**Letter of Intent
May 2018**

Project: Appaloosa Hwy 24 Subdivision Fil. No. 2

Applications/Project Description: This application is for the replatting of Lot 2 of the Appaloosa Hwy 24 Subdivision into three (3) lots.

APPALOOSA HIGHWAY 24 SUBDIVISION
FILING NO. 2
COLORADO SPRINGS, COLORADO
GRADING AND DRAINAGE PLAN

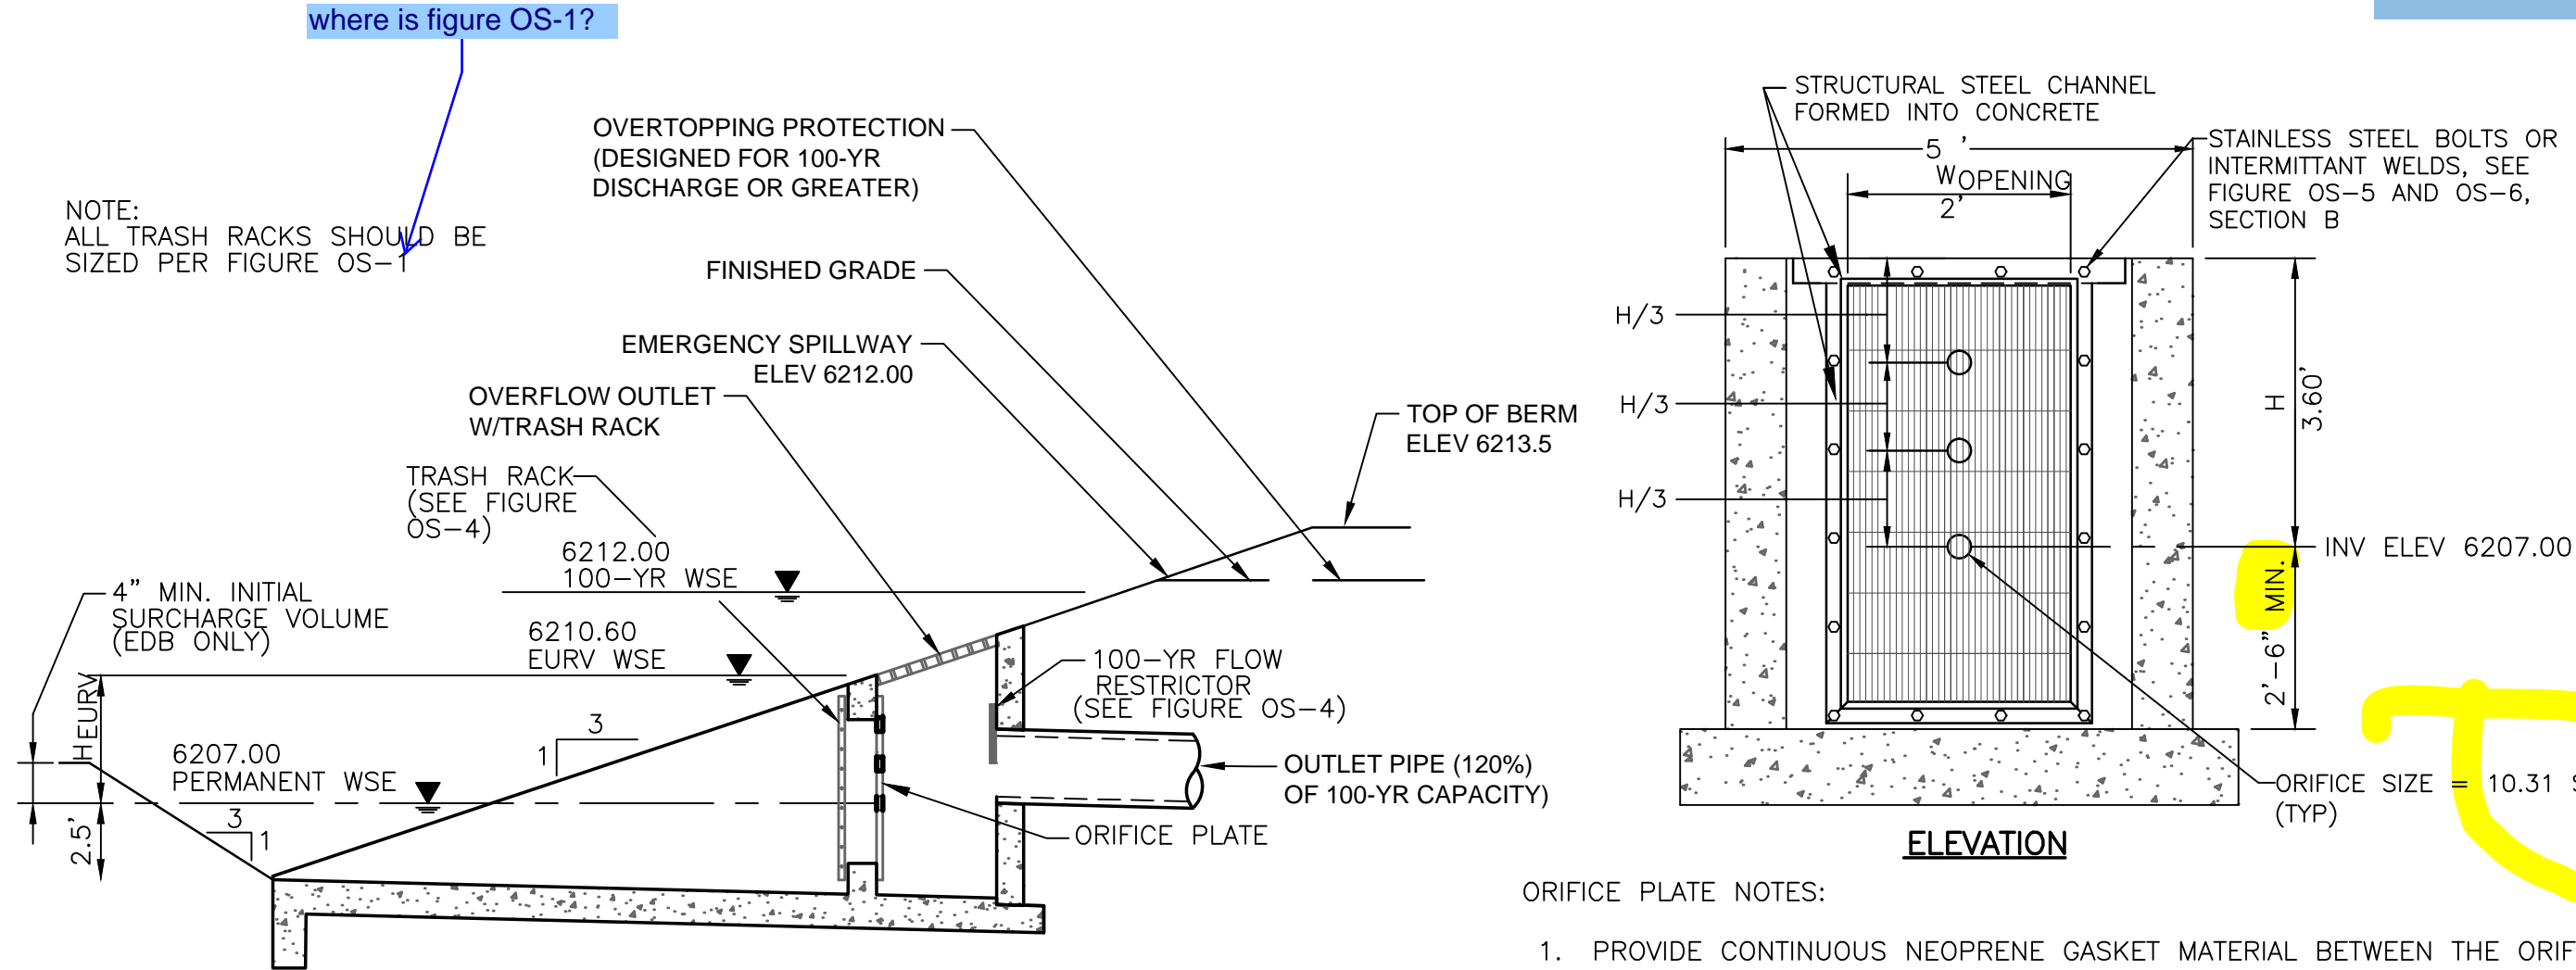
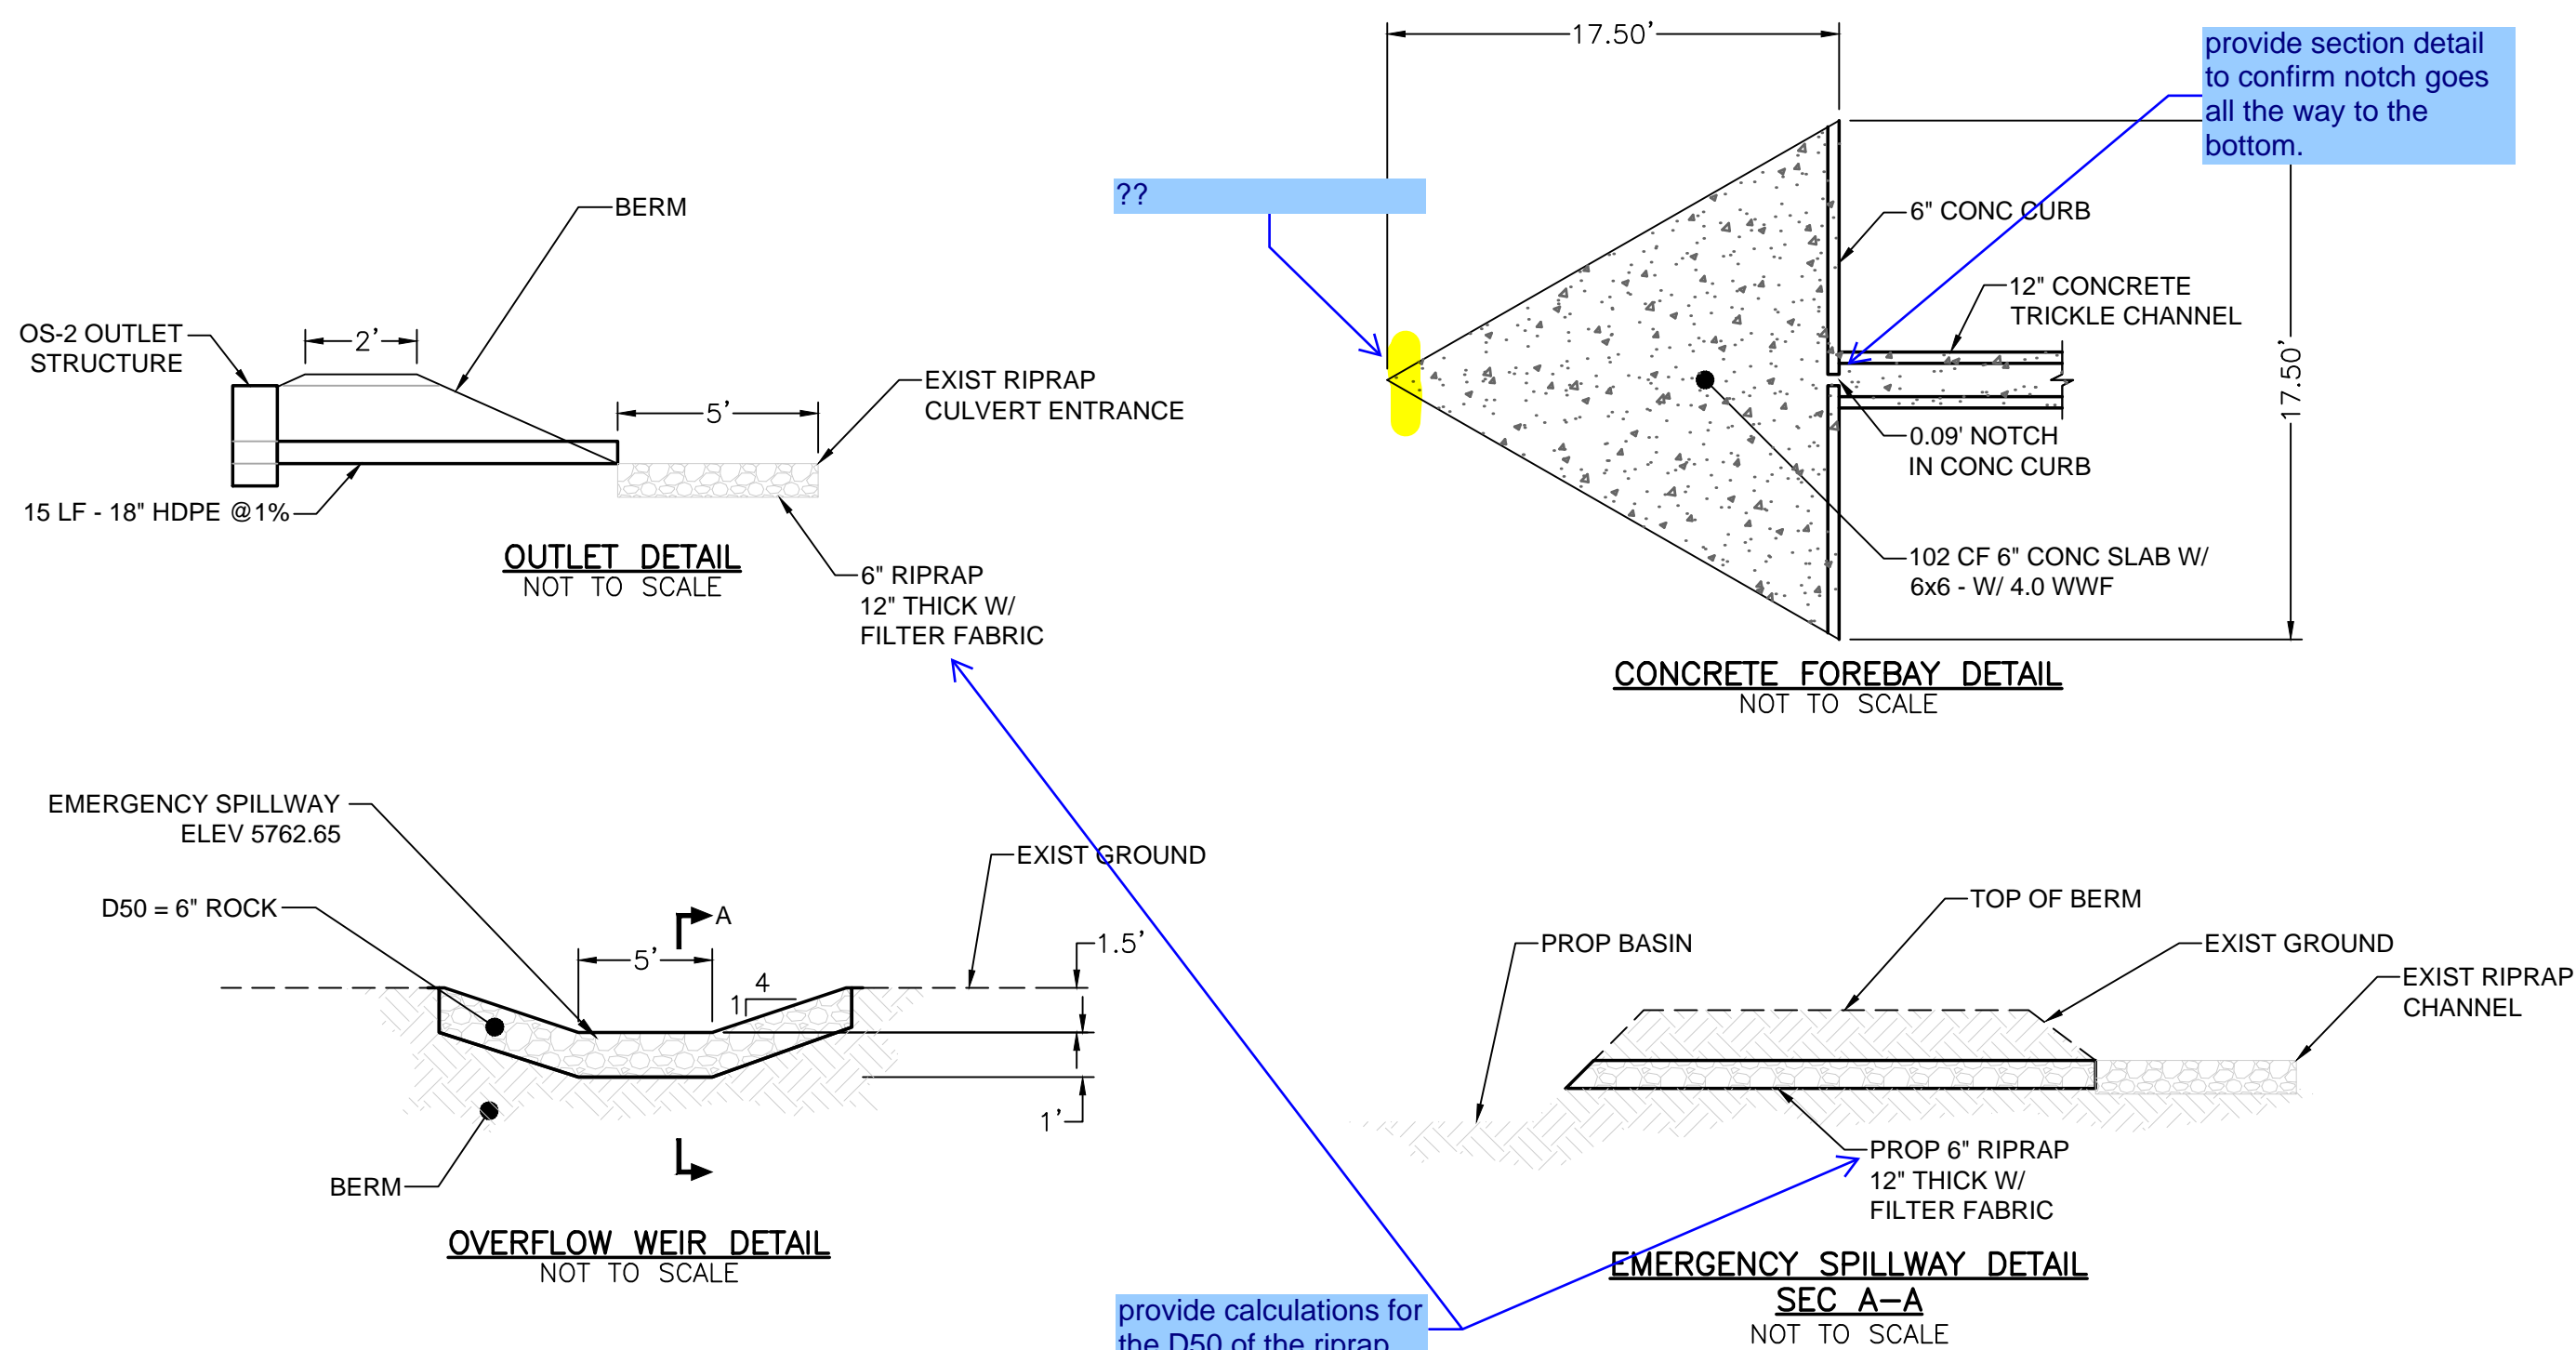
How is the detention pond going to be maintained? Common Ownership or maintenance?

please explain who will own and maintain the water quality pond and the channel.
